**Zipperer Short Plat - File Number SP-20-00005**  
**Condition Compliance Document**

<u>Approval Condition</u>	<u>Applicant Response</u>	<u>Staff Review</u>
<b>1. Building</b>		
A. All new construction must meet the International Building Code requirements.	Noted

ZIPPERER SHORT PLAT, SP-20-00005
A PORTION OF SECTIONS 21 & 28, TOWNSHIP 20 NORTH, RANGE 14 EAST, W.M., KITTITAS COUNTY, WASHINGTON

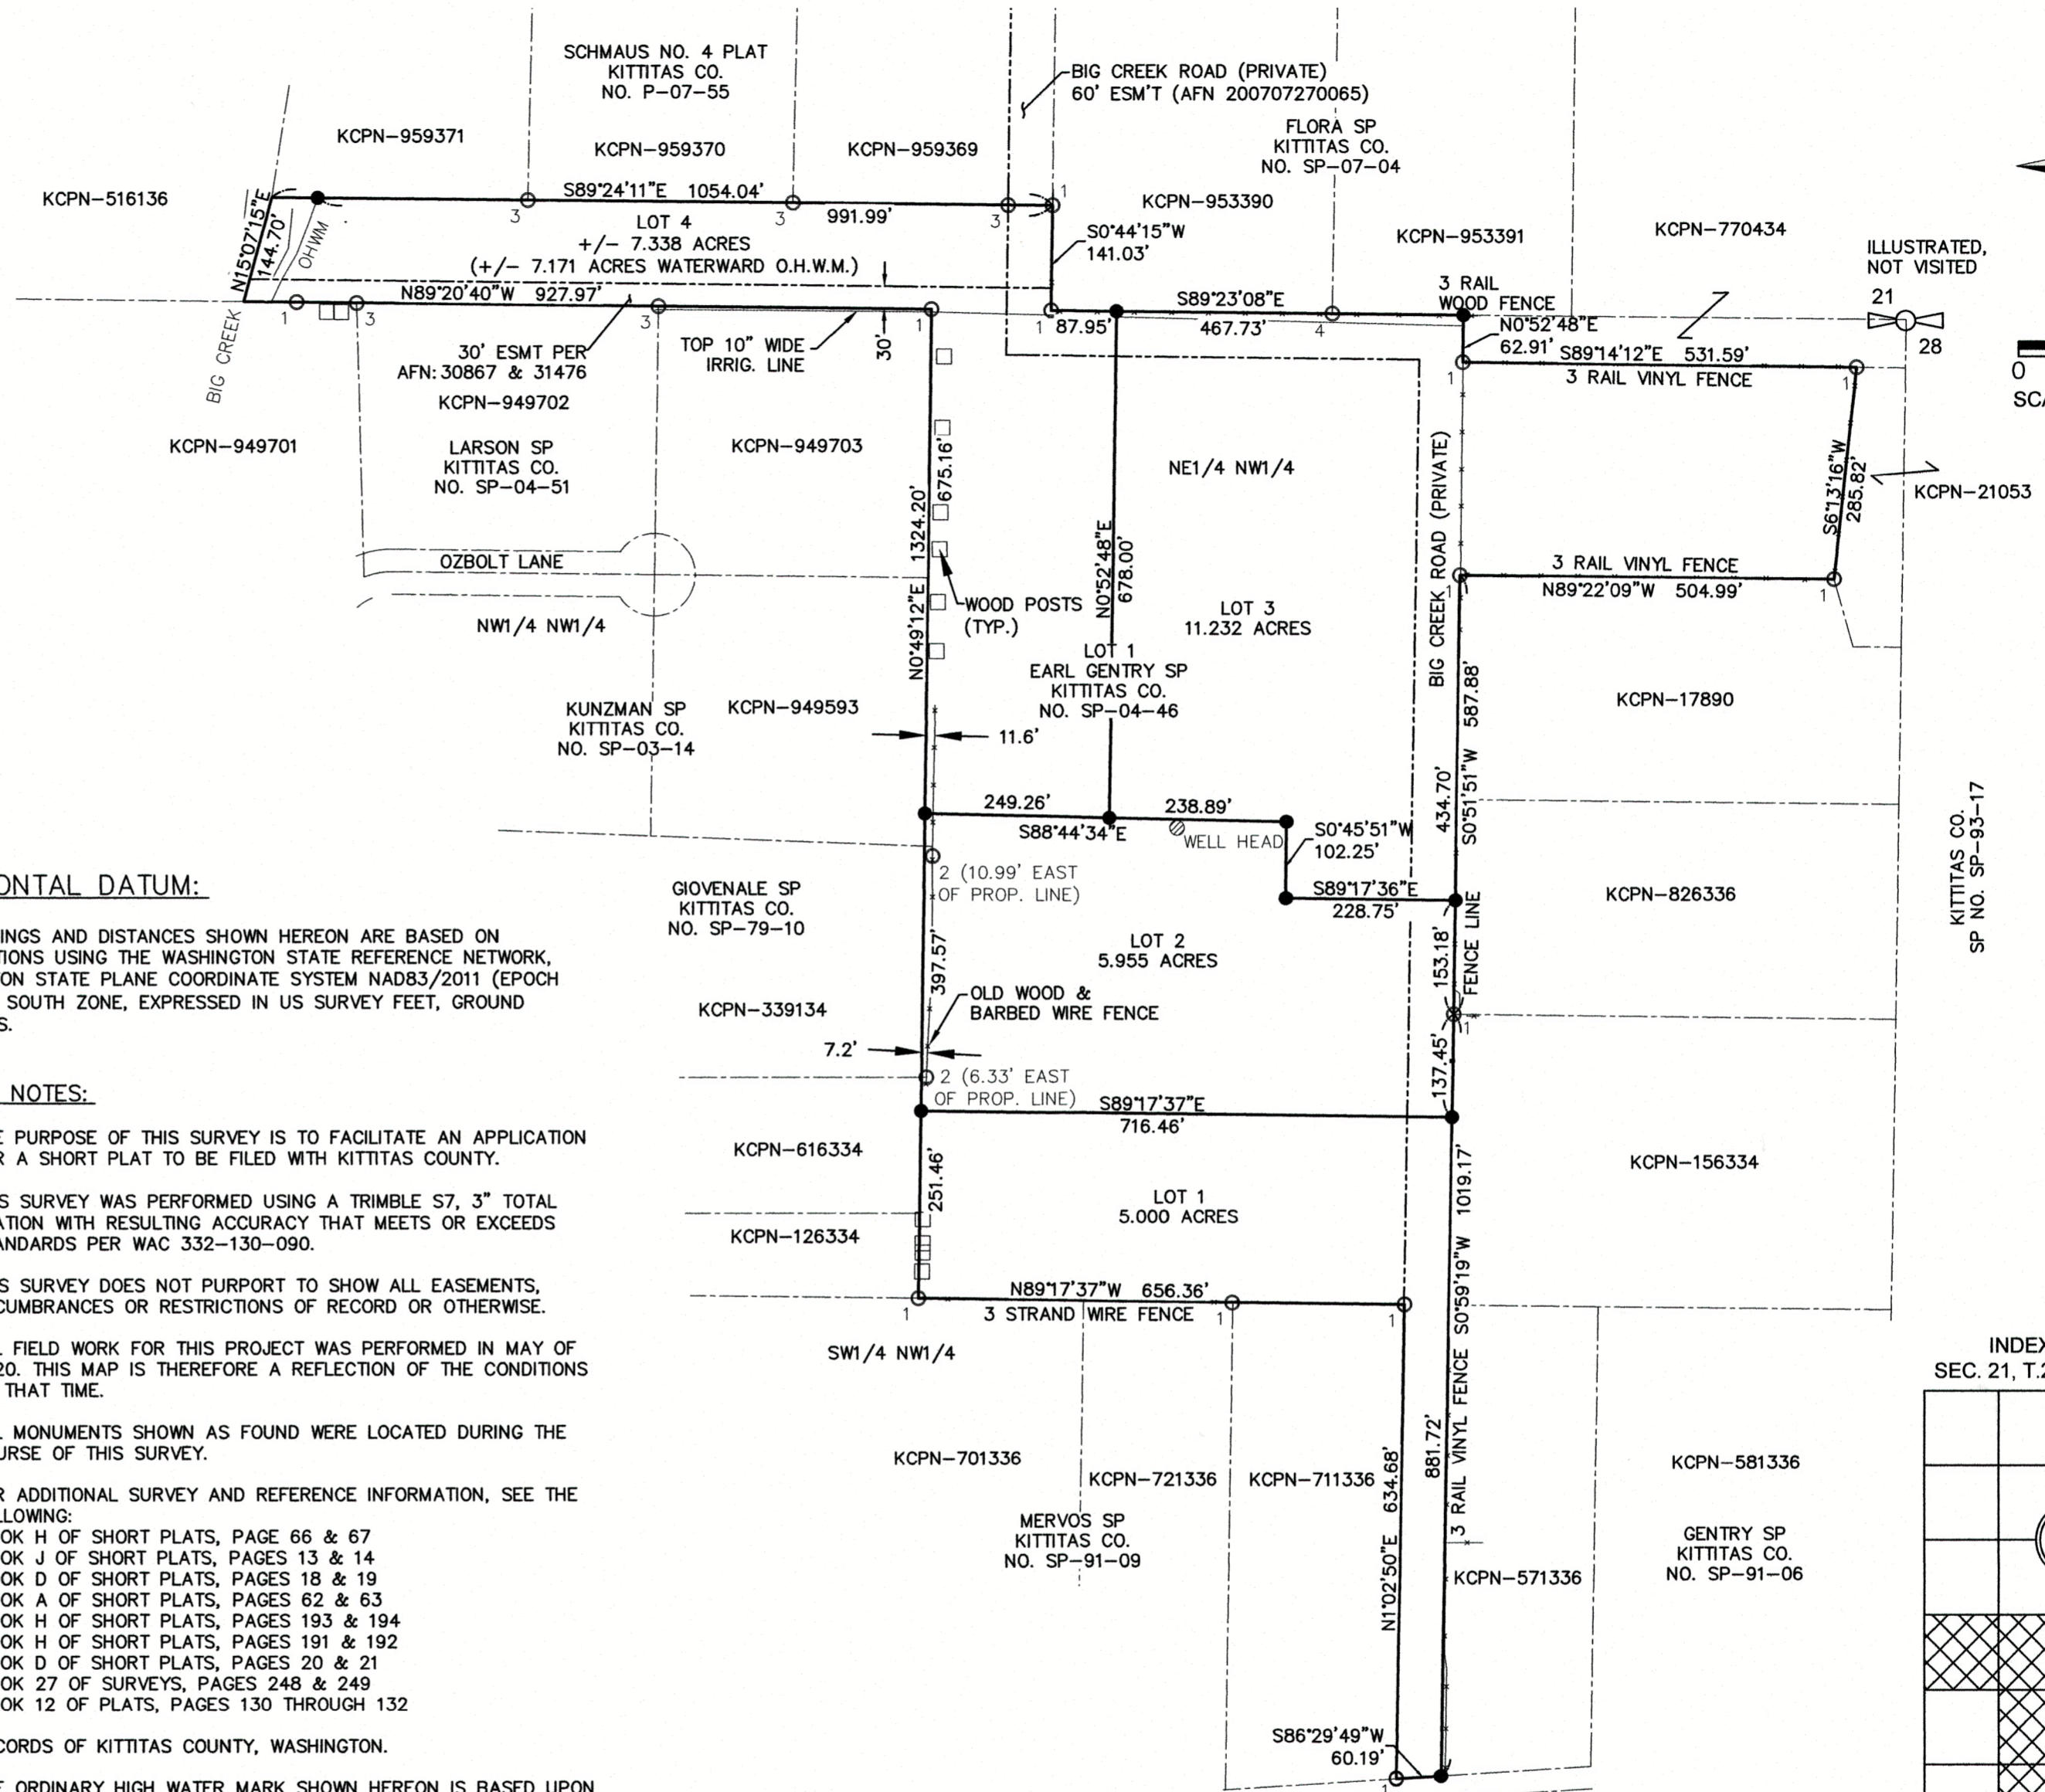
A. The following plat notes shall be recorded on the final mylar drawing:		
* Environmental and statutory review may be required for all current and future development, construction, and improvements. The applicant and/or all future owners of any lot or lots within this subdivision are responsible for compliance with all applicable local, state, and federal rules, requirements, codes, and regulations. It is incumbent upon said applicants and future owners to investigate for, and obtain from the appropriate agency or their representative, all required permits, licenses, and approvals for any development, construction, and/or improvements that occur within the boundaries of this subdivision.	Note 2 on Sheet 2

* All development must comply with International Fire Code.	Note 4 on Sheet 2	
* Maintenance of the access is the responsibility of the property owners who benefit from its use.	Note 5 on Sheet 2

* An approved access permit will be required from the Department of Public Works prior to creating any new driveway access or performing work within the county road right-of-way.	Note 6 on Sheet 2

* The approval of this division of land provides no guarantee that use of water under the ground water exemption (RCW 90.44.050) for this plat or any portion thereof will not be subject to curtailment by the Department of Ecology or court of law.	Note 9 on Sheet 2

* Metering is required for all new uses of domestic water for residential well connections and usage must be recorded in a manner consistent with Kittitas County Code Chapter 13.35.027 and Ecology regulations.	Note 8 on Sheet 2

* Any further subdivision or lots to be served by proposed access may result in further access requirements. See Kittitas County Road Standards.	Note 7 on Sheet 2

* A public utility easement 10 feet in width is reserved along all lot lines. The 10 foot easement shall abut the exterior plat boundary and shall be divided by 5 feet on each side of interior lot lines. Said easement may also be used for irrigation.	Note 1 on Sheet 2	
--	-------------------	--

**ZIPPERER SHORT PLAT, SP-20-00005  
 SPF-21-00002**  
 A PORTION OF SECTIONS 21 & 28, TOWNSHIP 20 NORTH, RANGE 14 EAST, W.M., KITTITAS COUNTY, WASHINGTON

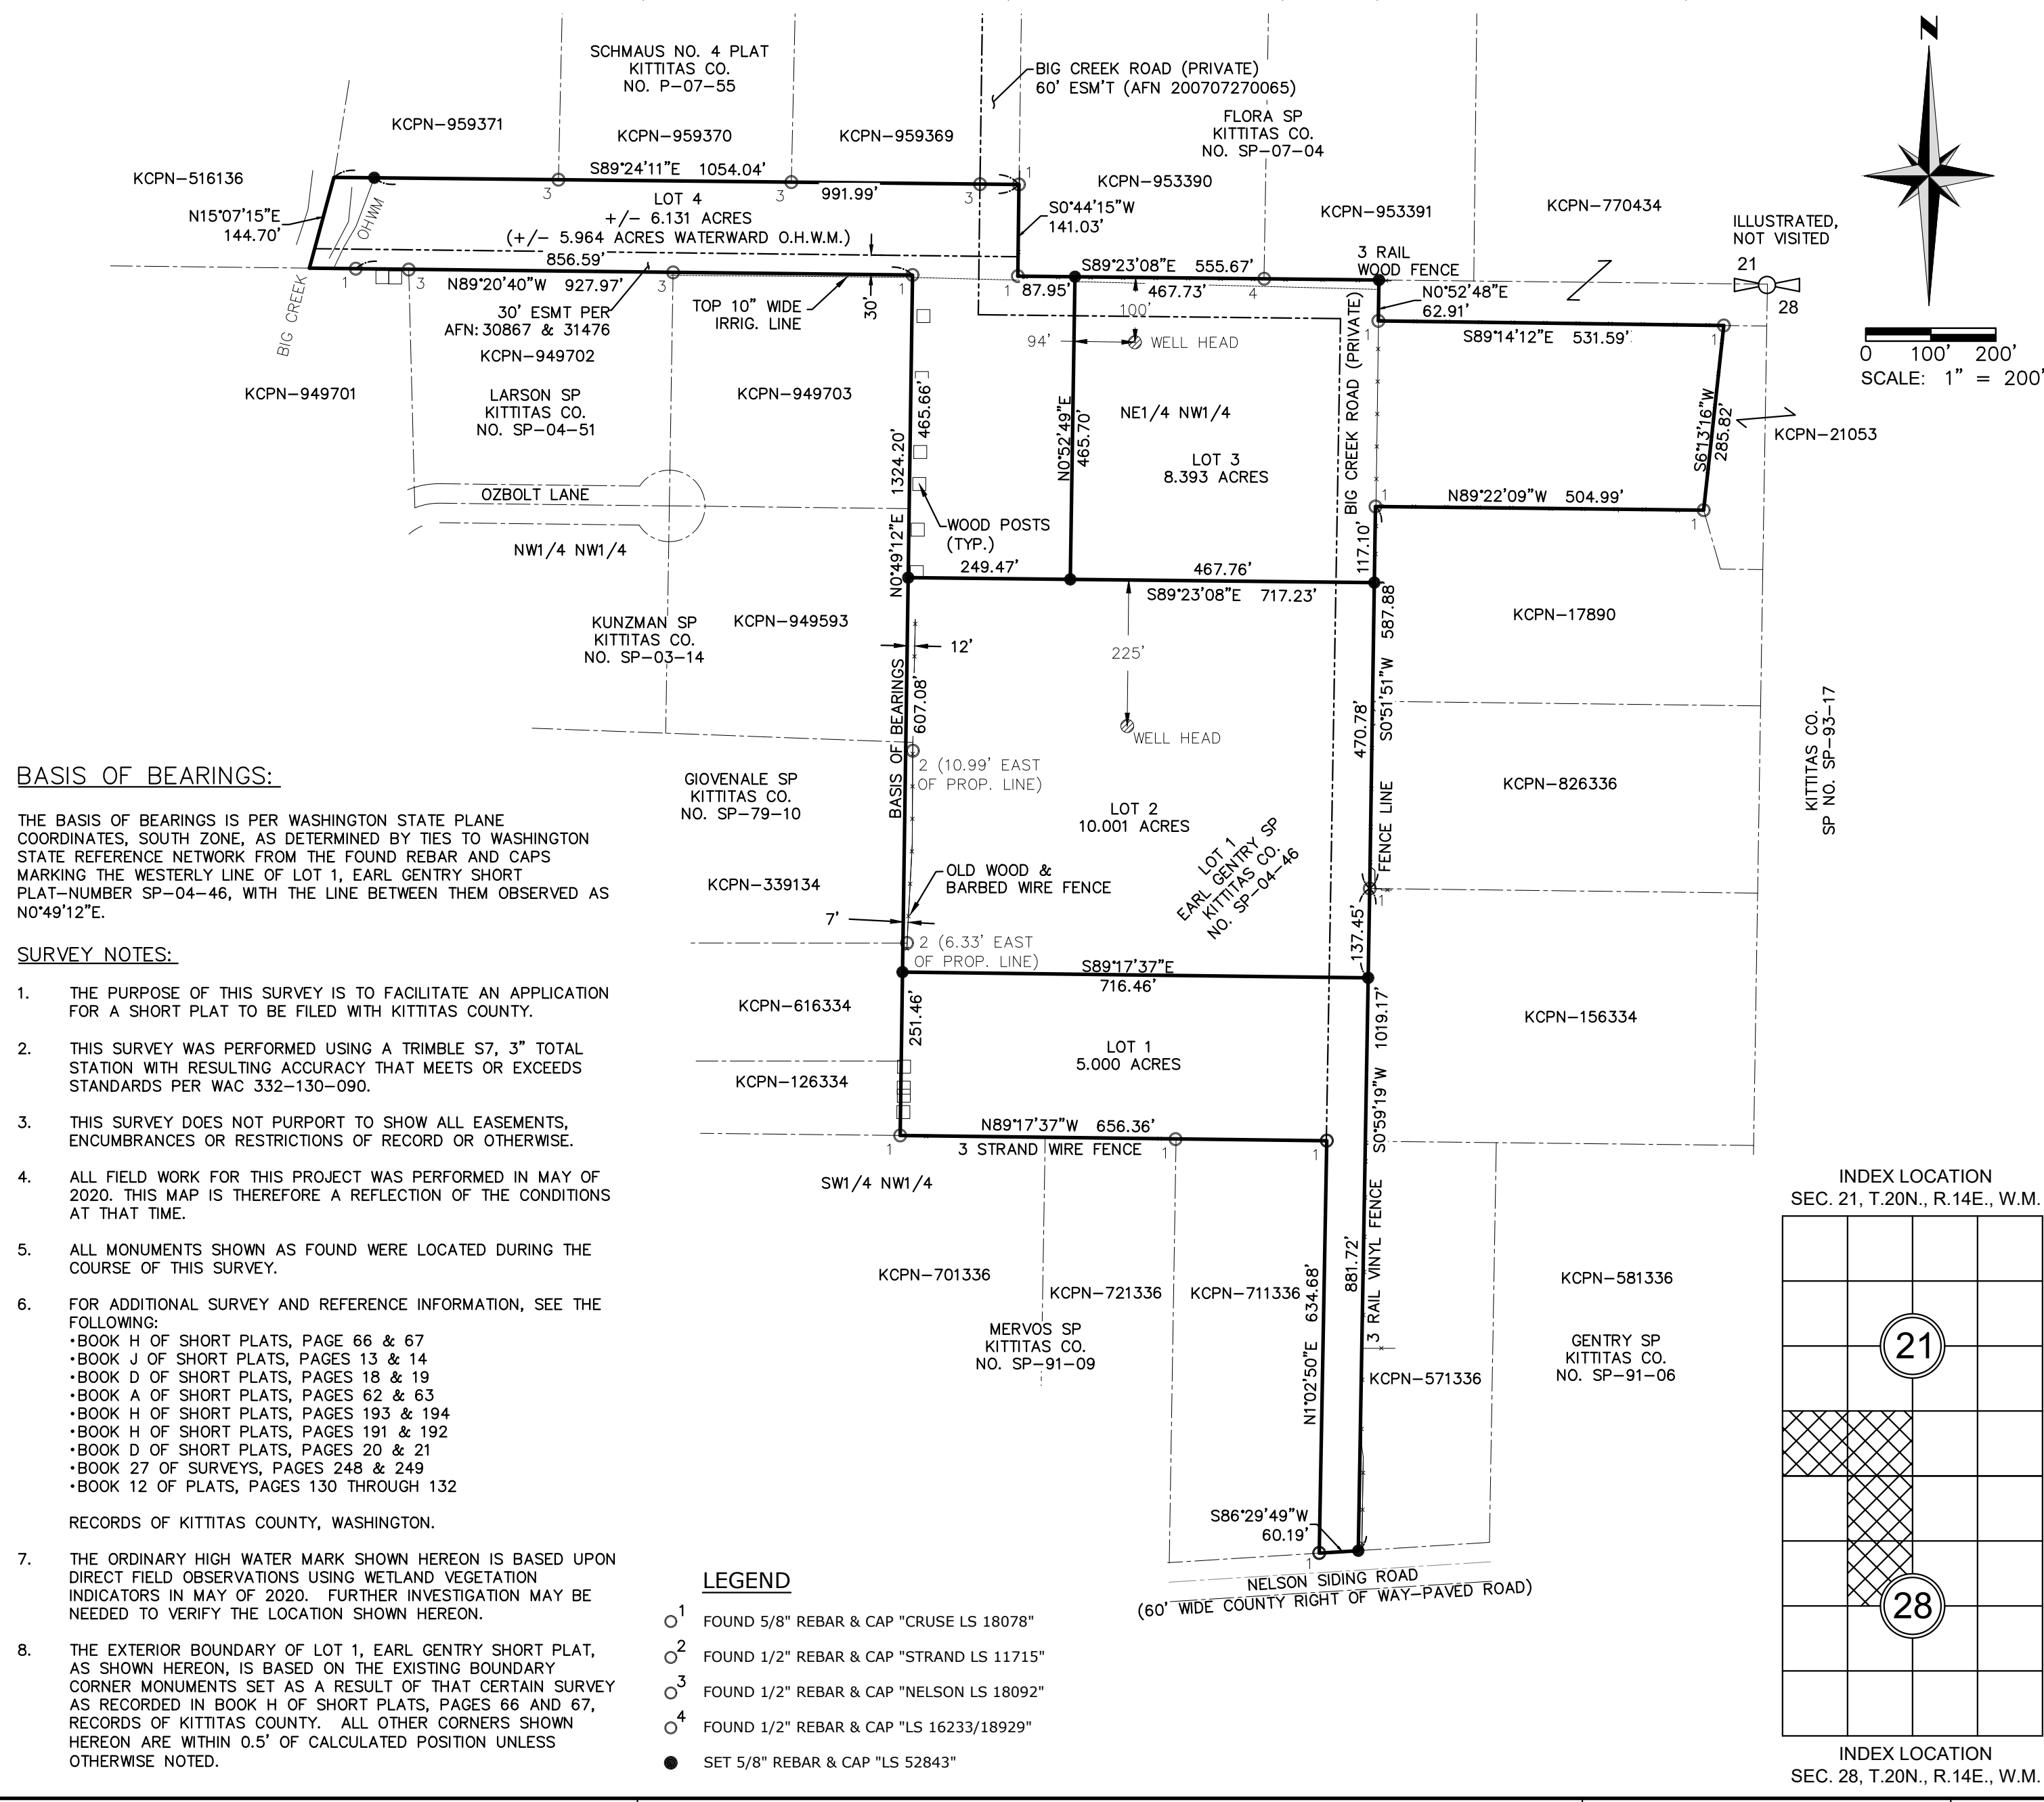
<b>6. Survey</b>		
A. Basis of bearing will need to be addressed.	Basis of bearing is addressed under Horizontal Datum on Sheet 1	
B. Note the distance the fence line encoraches into Lots 2 and 4.	Requested distances added

C. Show Nelson Siding Road as a "60' wide county right-of-way-paved".	Requested verbiage added	
D. "Tick marks" to the angle point that is on the East side of Lot 2 would be useful to clarify where the angle occurs.	Requested tick marks added

F. Typo in the existing leal description "inn".	Revised	
G. Some text obscured by crossing linework.	Crossing linework trimmed
